# UTE PASS SUMMER HOMES COMPANY SUB. NO. 1A

A VACATION AND REPLAT OF LOTS 92 AND 93  
 UTE PASS SUMMER HOMES COMPANY SUB. NO. 1  
 A PORTION OF THE SOUTHEAST QUARTER OF THE SOUTHWEST QUARTER OF  
 SECTION 15, TOWNSHIP 13 SOUTH, RANGE 68 WEST OF THE 6TH P.M.  
 EL PASO COUNTY, COLORADO

ZYTKA.dwg  
 JULY 18, 2018  
 PROJECT 16015  
 SHEET 1 OF 1

# Markup Summary

UTE PASS SUMMER HOMES COMPANY SUB. NO. 1A

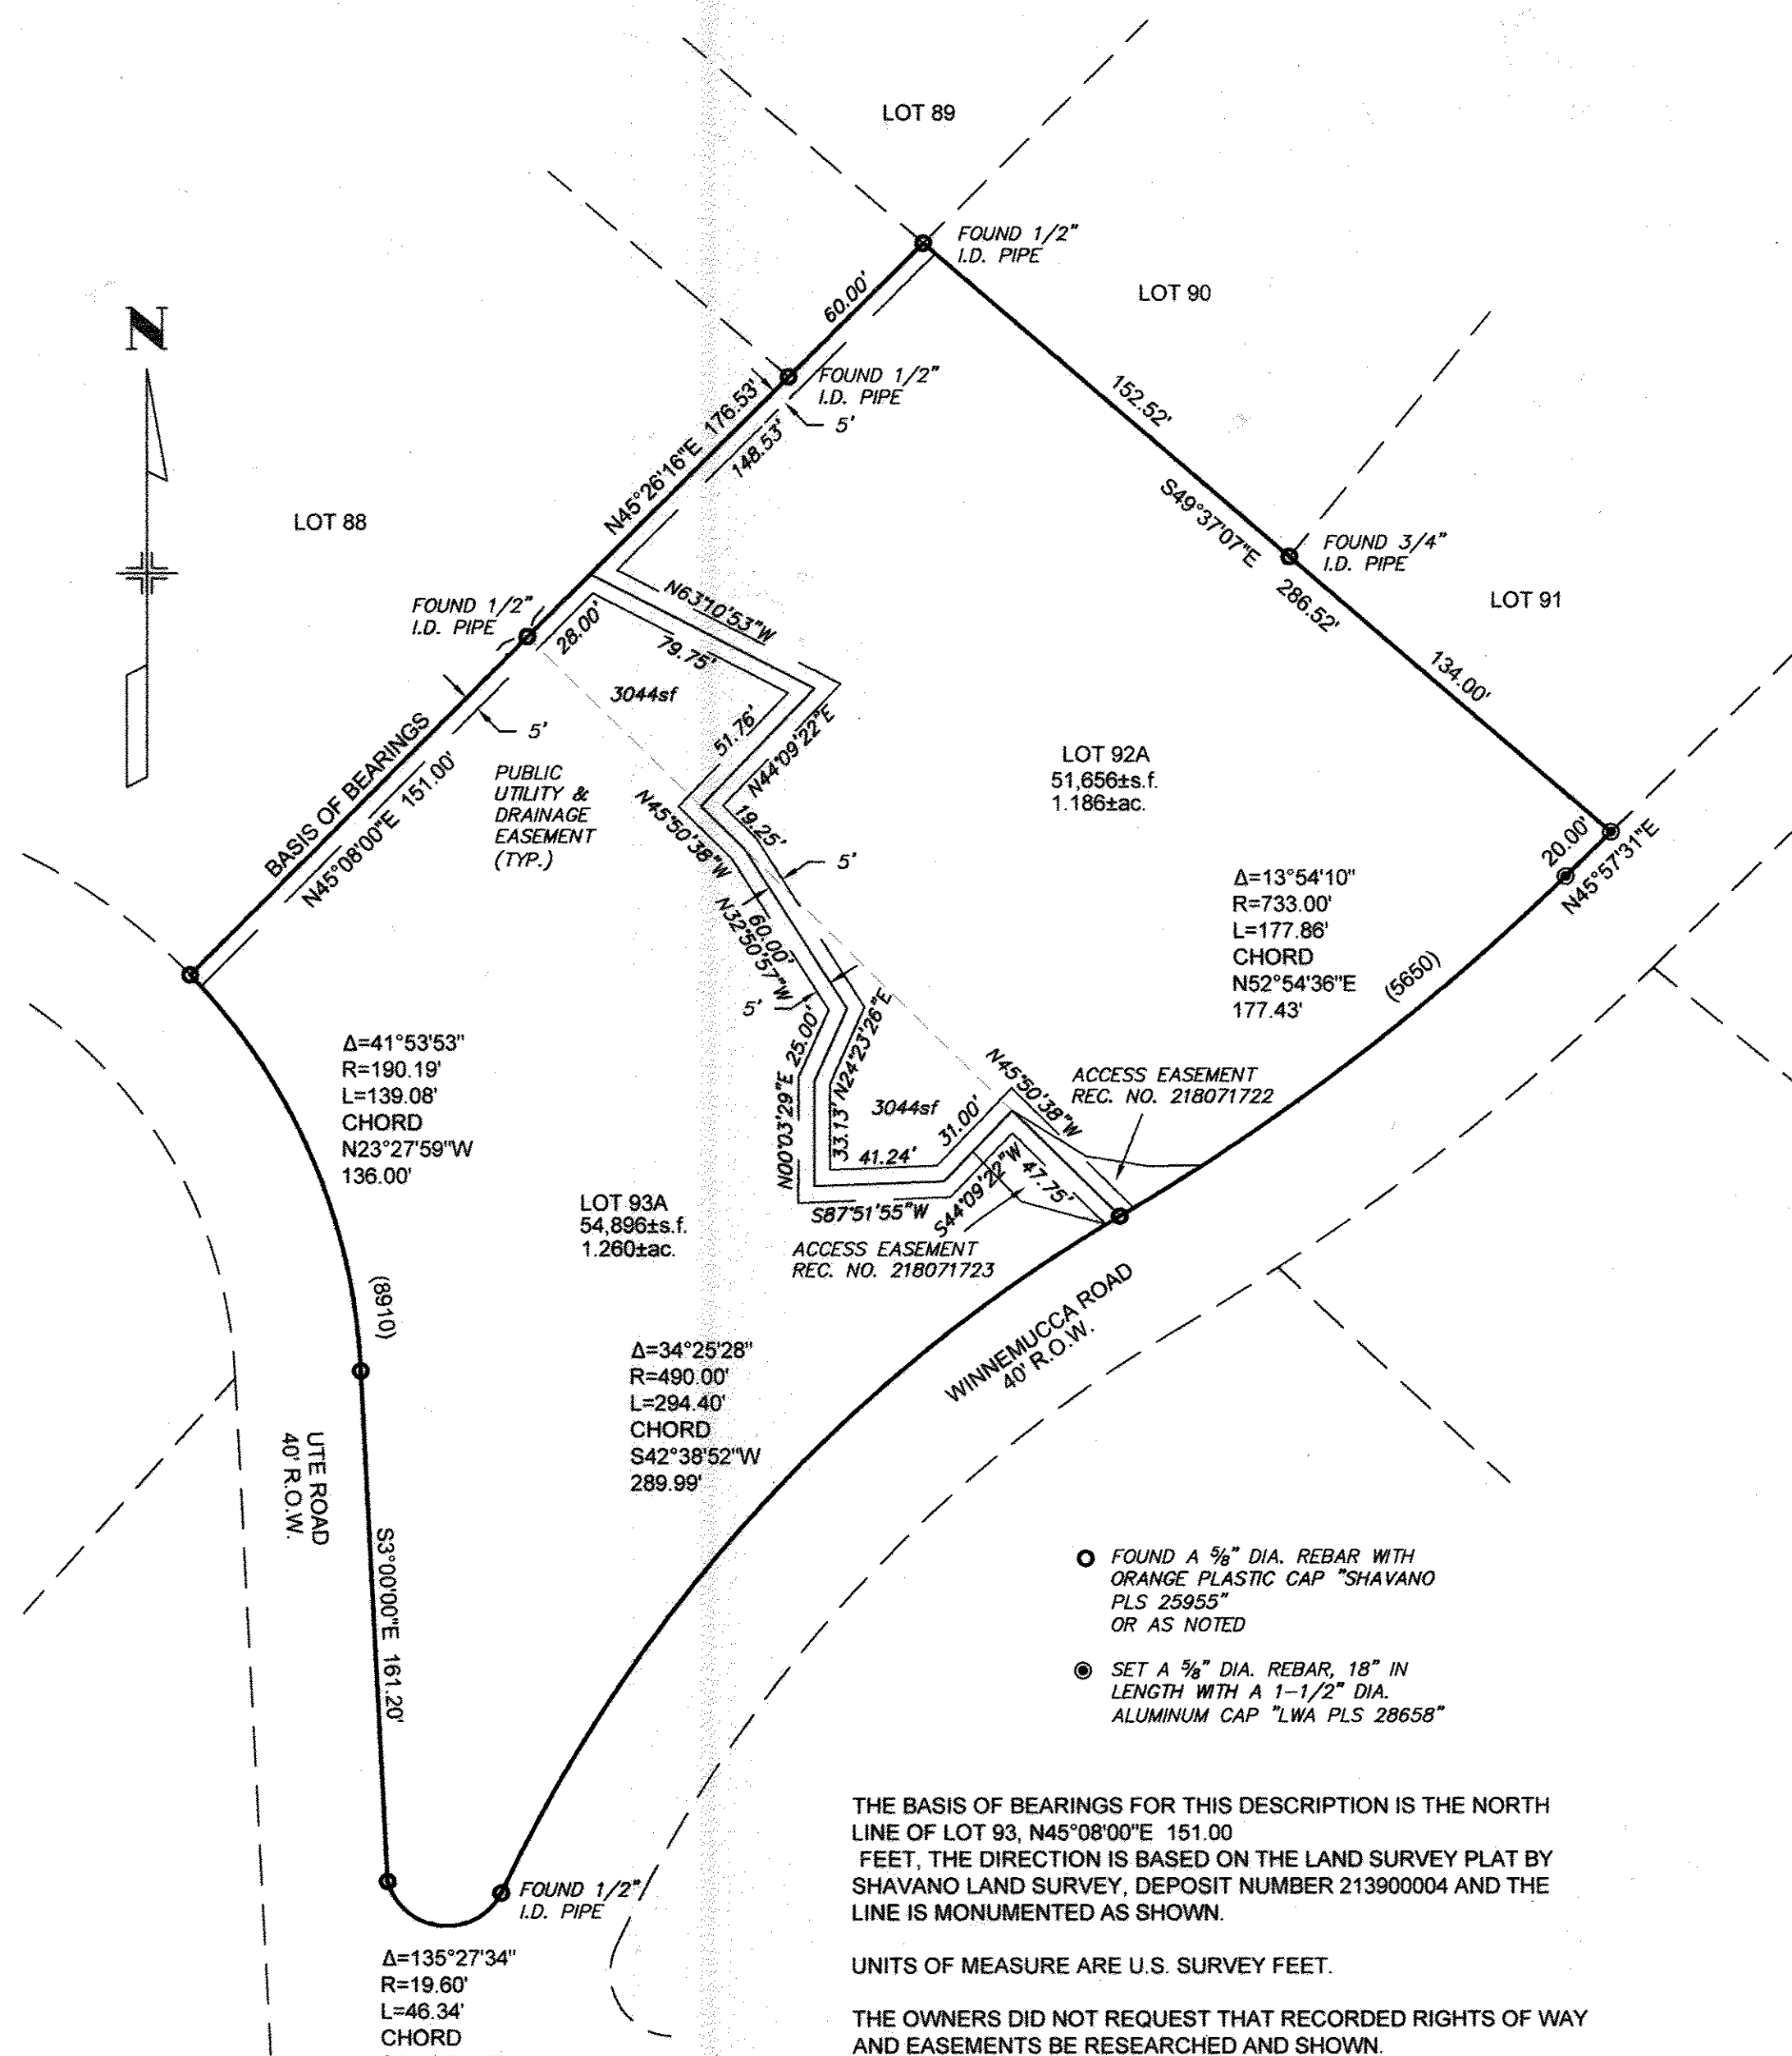
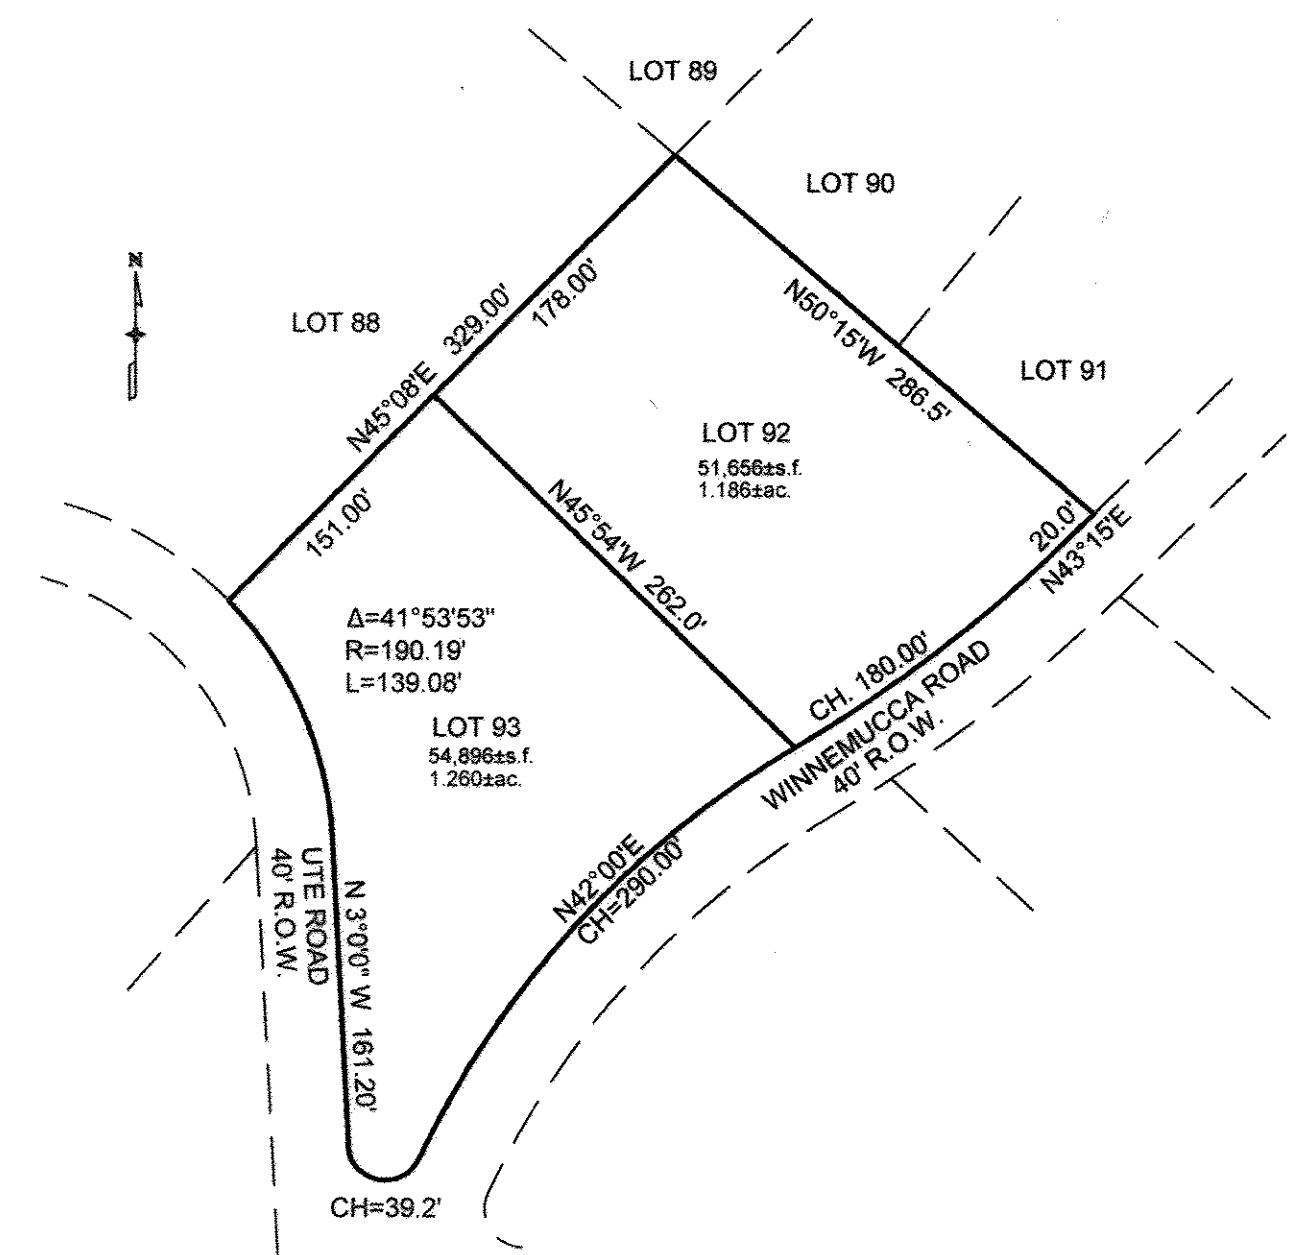
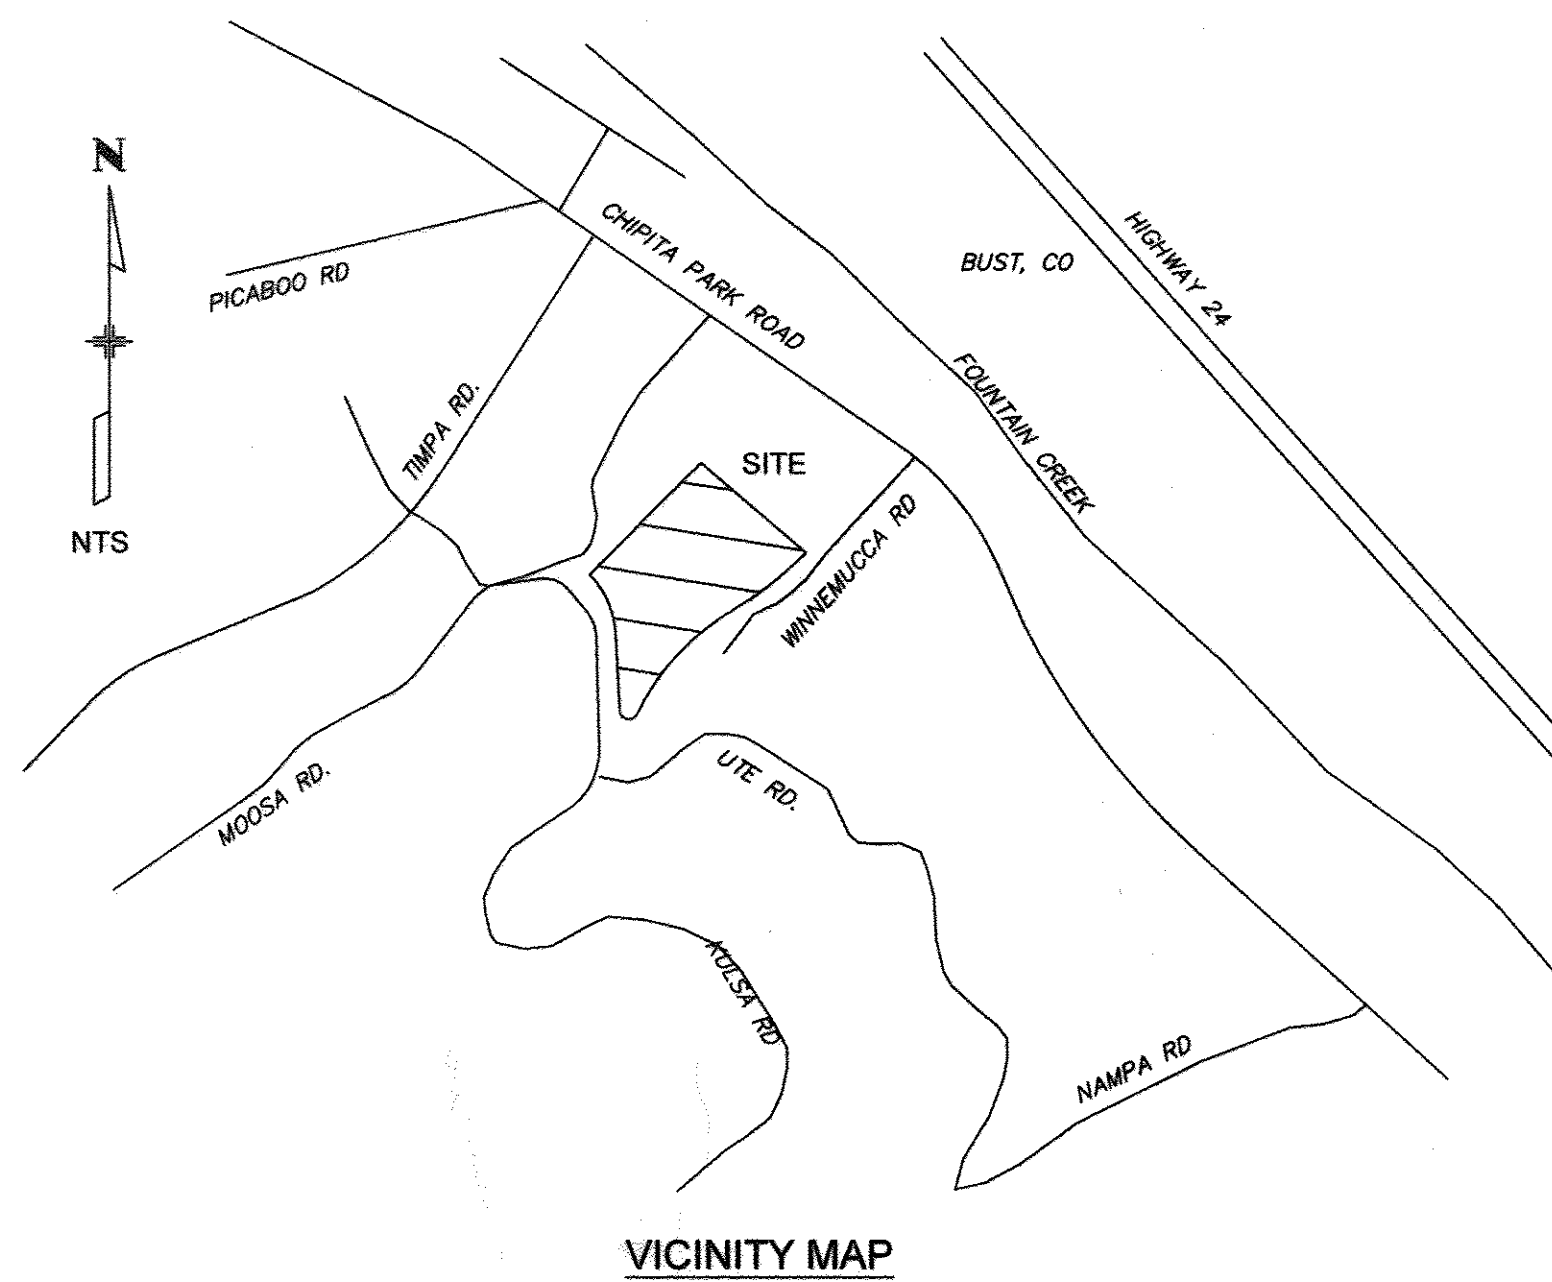
RESEARCH FOR RECORDED RIGHTS OF WAY AND EASEMENTS WAS DONE BY \_\_\_\_\_

Who was this research done by?
